## **East Park Energy: outstanding technical issues, evidential gaps and unresolved Examination matters**

Submission: Comments on Applicant Response to Deadline 4 Representations and Applicant's Deadline 5 Cover Letter

ILLUSTRATIVE SECTION THROUGH TYPICAL ACCESS TRACK

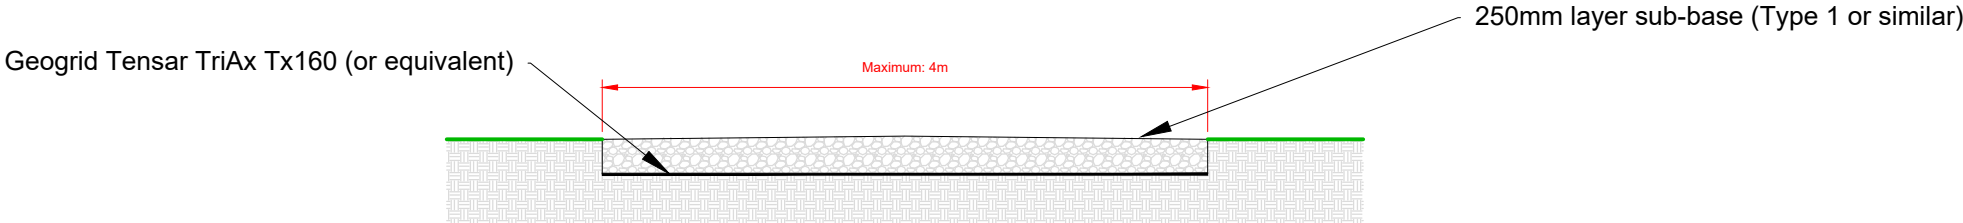
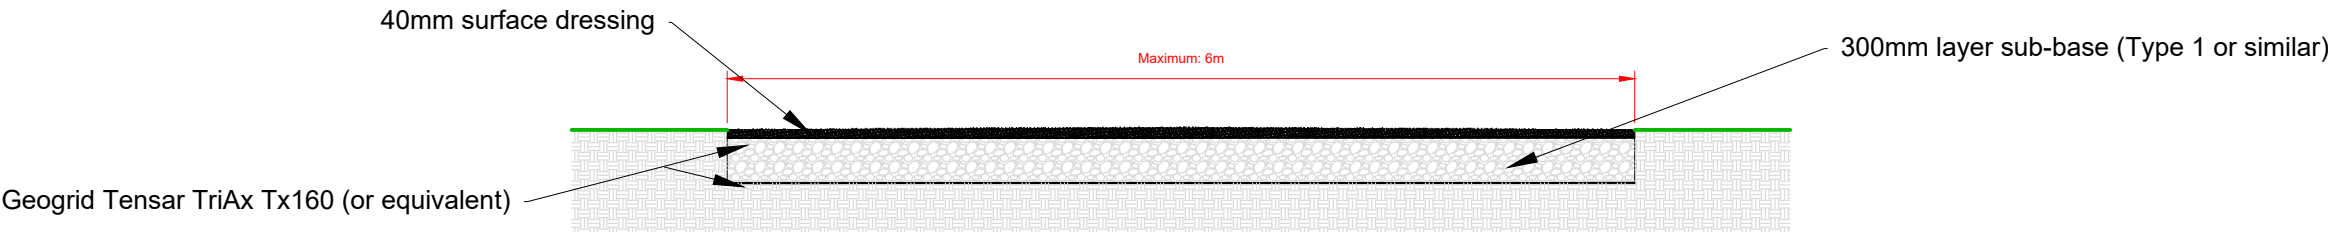
Similarly, SEPE contends that design parameters (2.2.24) are limited in detail. For example, for access tracks, Table 6 of the Applicant's Design Parameters and Principles Statement (REP4-023) states for Work No 6, 'Scale':

"The access tracks will have a width of up to 4m, and a depth of up to 0.25m below ground level."

SEPE is concerned that the 0.25m depth is insufficient for HGVs and could damage the subsoil. The Applicant should provide pavement calculations to demonstrate that its track design is adequate.

By comparison, the Scheme component 'BESS Internal Access' (Work No 2) for 'Design' has the following applicable design parameter:

"The BESS compound internal access roads will be up to 6m wide and up to 0.5m depth below ground level."

The same applies for 'Substation Internal Access' (Work No 3), under 'Design'. It has not been made clear why the pavement thickness is double at these locations compared to the remaining sections of access tracks.

ILLUSTRATIVE SECTION DRAWING OF OPEN SPAN CROSSING OF FIELD DITCH

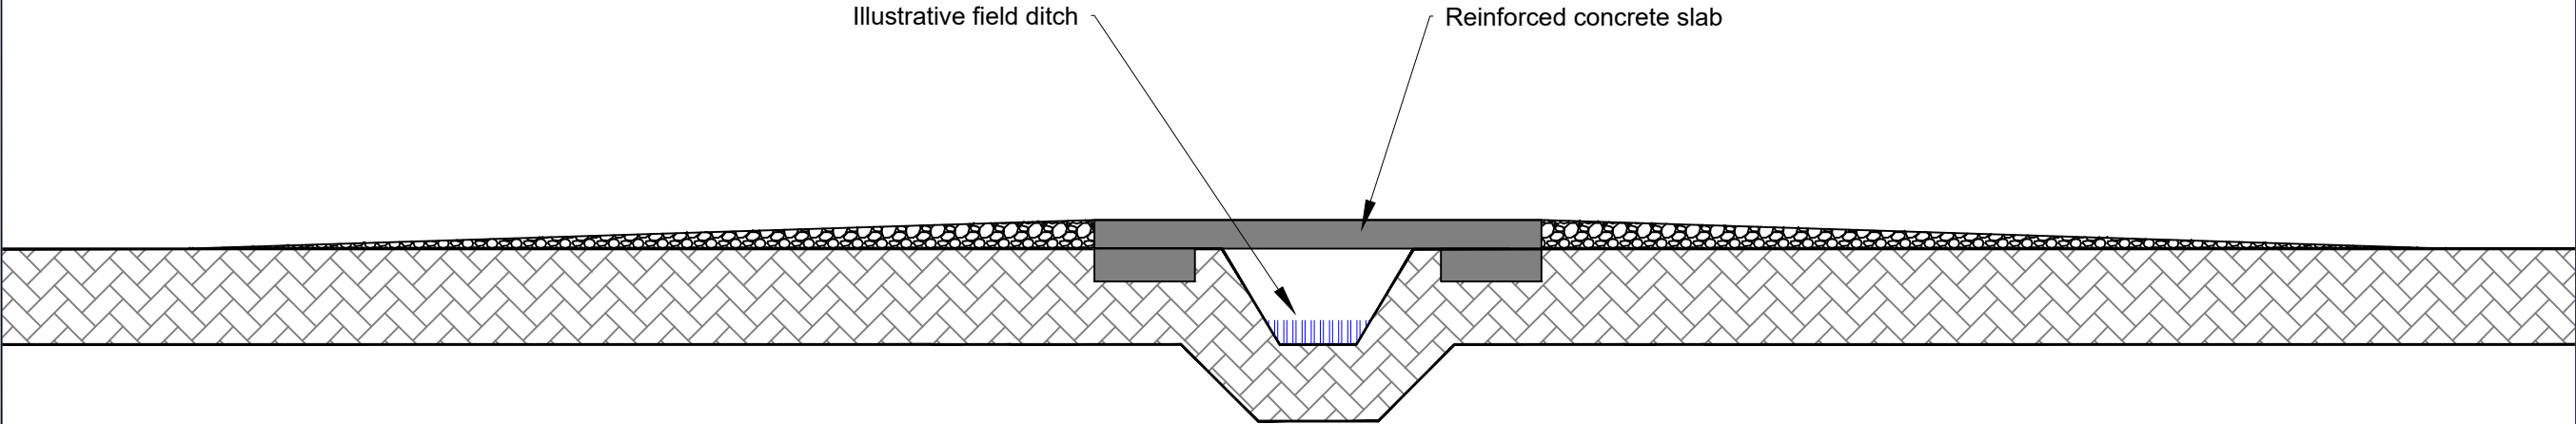
Similarly, SEPE suggests that it is not clear what type of "open-span crossing" (Work No 6) is proposed at water crossings (Table 6, 'Design') that will not cause flooding issues. The Applicant does not provide details.
